ABE
Community
Land
Trust

Nyton Lodge,
Nyton Road,
Westergate,
Chichester,
PO20 3UL

RE: AL/21/20/OUT – Comments from ABE CLT

Land At Lidsey Road
Proposed Site Plan [DRAFT FOR COMMENT]

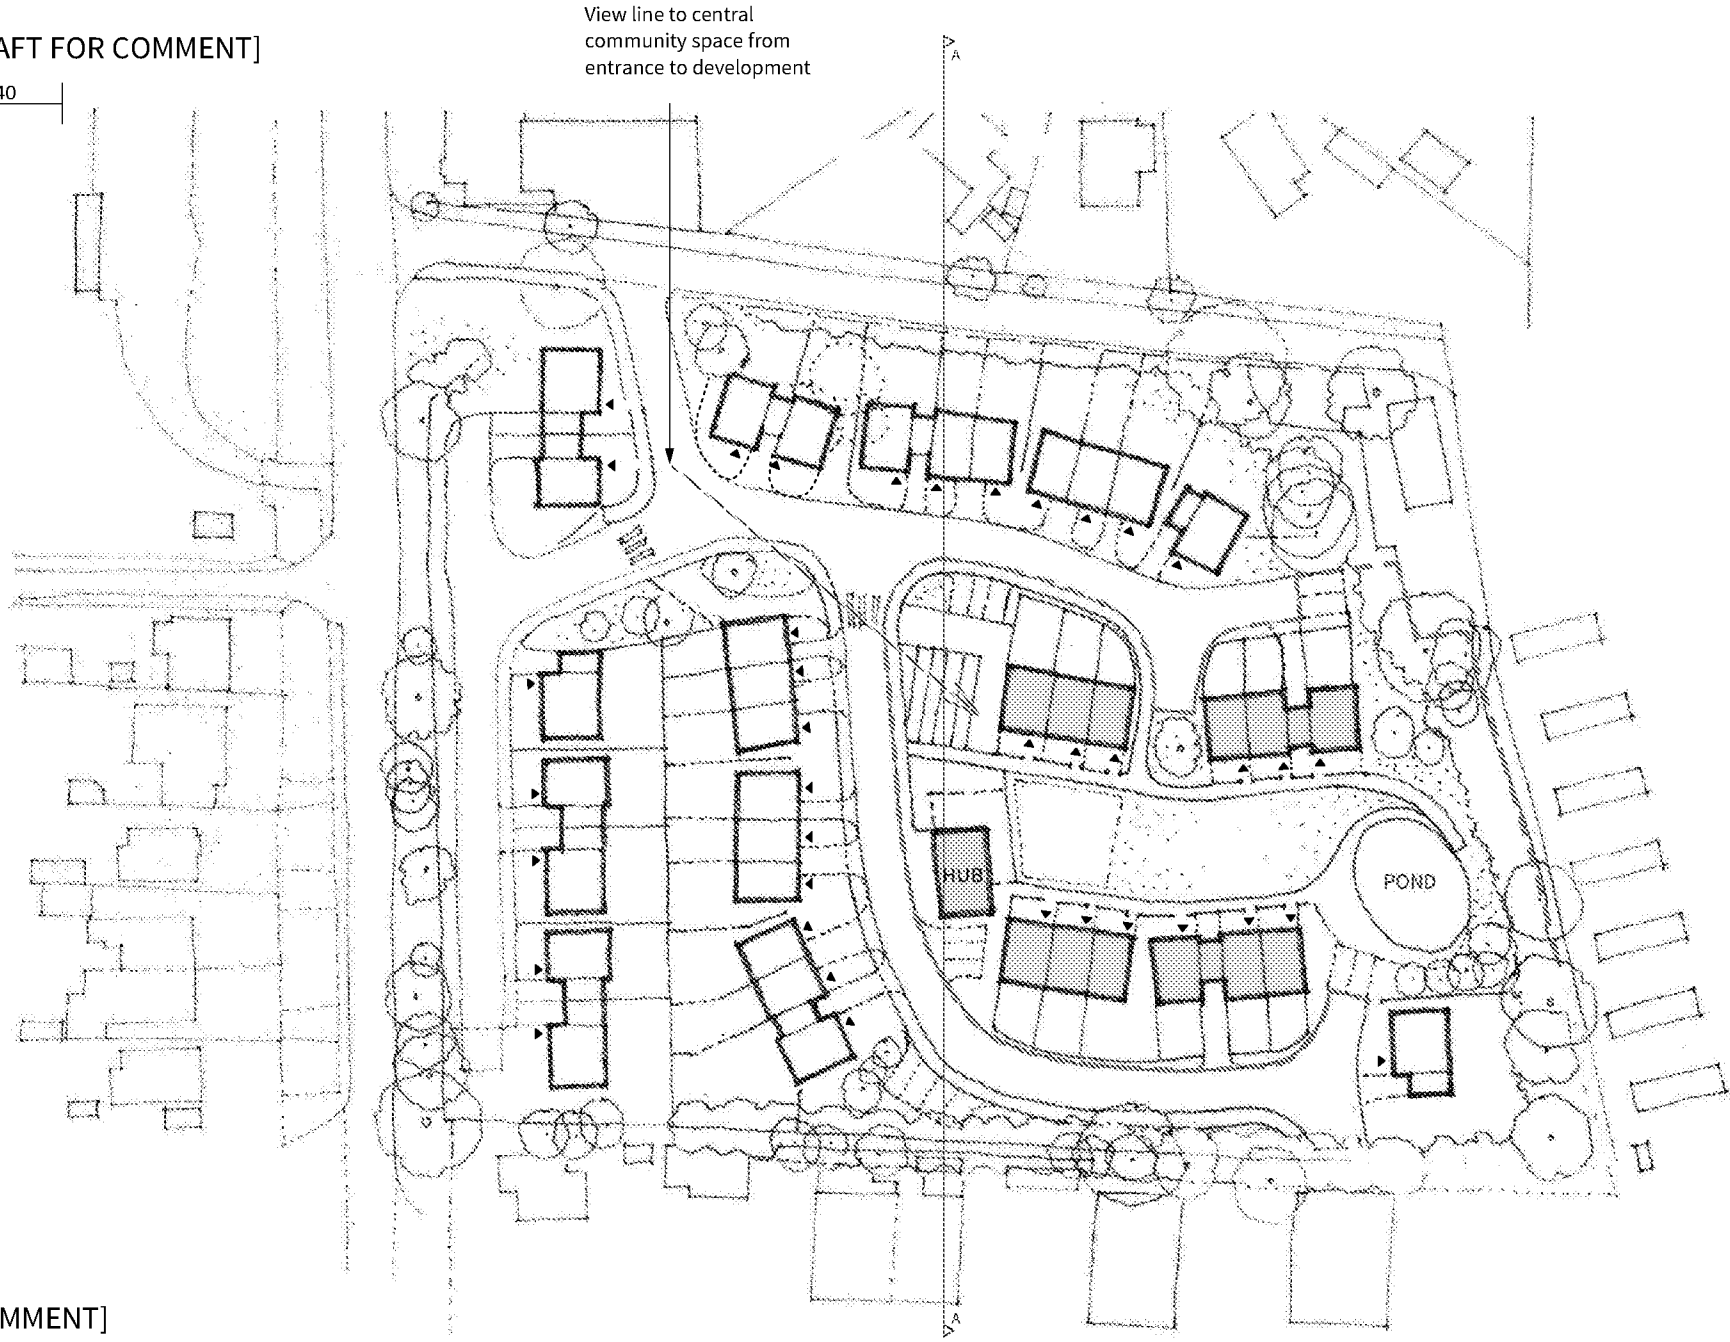
4. While the grouping of the affordable units offers benefits in terms of management and avoiding isolation it would be preferable in the context of a rural location if the development were more “tenure blind”. The scale of the development makes “Pepper potting” more difficult / less necessary. However, we would ask that two of the blocks of three homes for sale are swapped with two of the affordable blocks of 3 homes – one in to the north and one to the west of the site to provide a more mixed / balanced / sustainability community and avoiding a ‘them and us’ appearance / lived experience.

5. We support the aspirations for providing plenty of green space in a central area, biodiversity and drainage provision. However, the parking provision is low at one space per unit and this may be considered insufficient in the context of a rural location with an infrequent bus service. Consequently we are concerned that more parking provision may be required, reducing the provision of green space, and fundamentally undermining one of the attractive points and aspirations set out for the development. It may help if the applicants were asked to clarify how any additional parking requirement would be addressed and if the application were to provide clear connectivity with the proposed Barnham – Westergate cycle link.

6. The porous paving proposed could be costly to maintain and it is not designed for heavy use. The pond, which is part of the SUDS, does not have access designated for maintenance purposes (a flaw in the design of the Hook Lane SUDS which had to be addressed following expert advice). The obvious point of access is shown as a double parking area, and this would require management (eg a gate and signage) to ensure that access is available when required and that it does not form part of a domestic property.
